Our Ref: Modifications to Harbour Control Tower Demolition

SafeWork NSW has reviewed the various documents in relation to the Modification Request for Barangaroo Headland Park & Northern Cove Main Works, Barangaroo (MP10_0048 MOD 8) – Demolition of Harbour Control Tower. In particular a review of the following documents has been undertaken:

11.1.3 Installation of the XL Platform System and Alimak Hoist

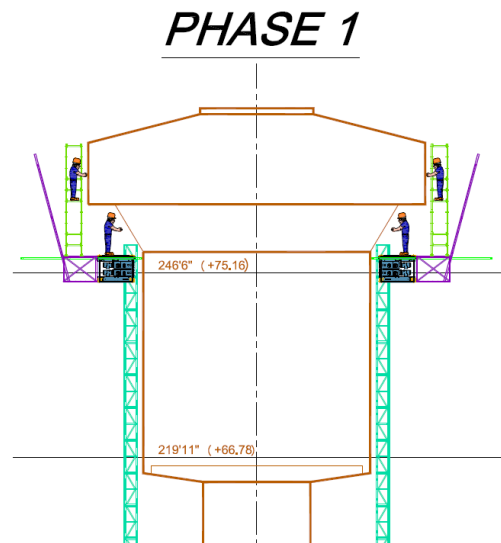
- No information on the structural capacity of the platforms for plant & equipment, personnel and demolition rubble and debris.
- No detail on adding inner section as transition to under the control room
- How will dust suppression occur on the XL platform?
- How will falling objects be controlled from the XL platform? Will there be gaps through which rubble can fall?
- No information on the interaction of the Alimak with the XL platform. How will access to the platform be designed without leaving rubble gaps?

11.1.6 Phase #3 Demolition

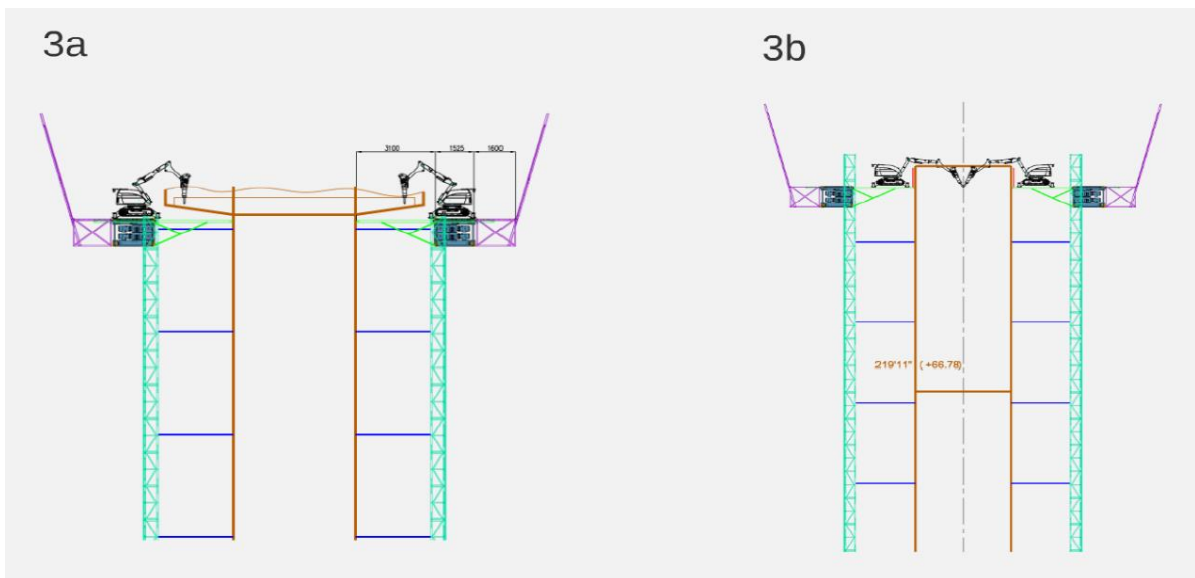
- Where will operators of the two demolition robots be positioned whilst demolition work will be occurring?
- Although predominantly an EPA issue, noise from pulverising concrete (and hammering if pulverising is not effective) will result in noise exceedance. The noise and vibration assessment report states, *“Of the remaining methodologies, the structural dismantling option will result in the lowest number of demolished elements, minimising the overall risk exposure to surrounding community, number of exclusion zones and noise impacts to surrounding receivers, and hence is the preferred option”*.
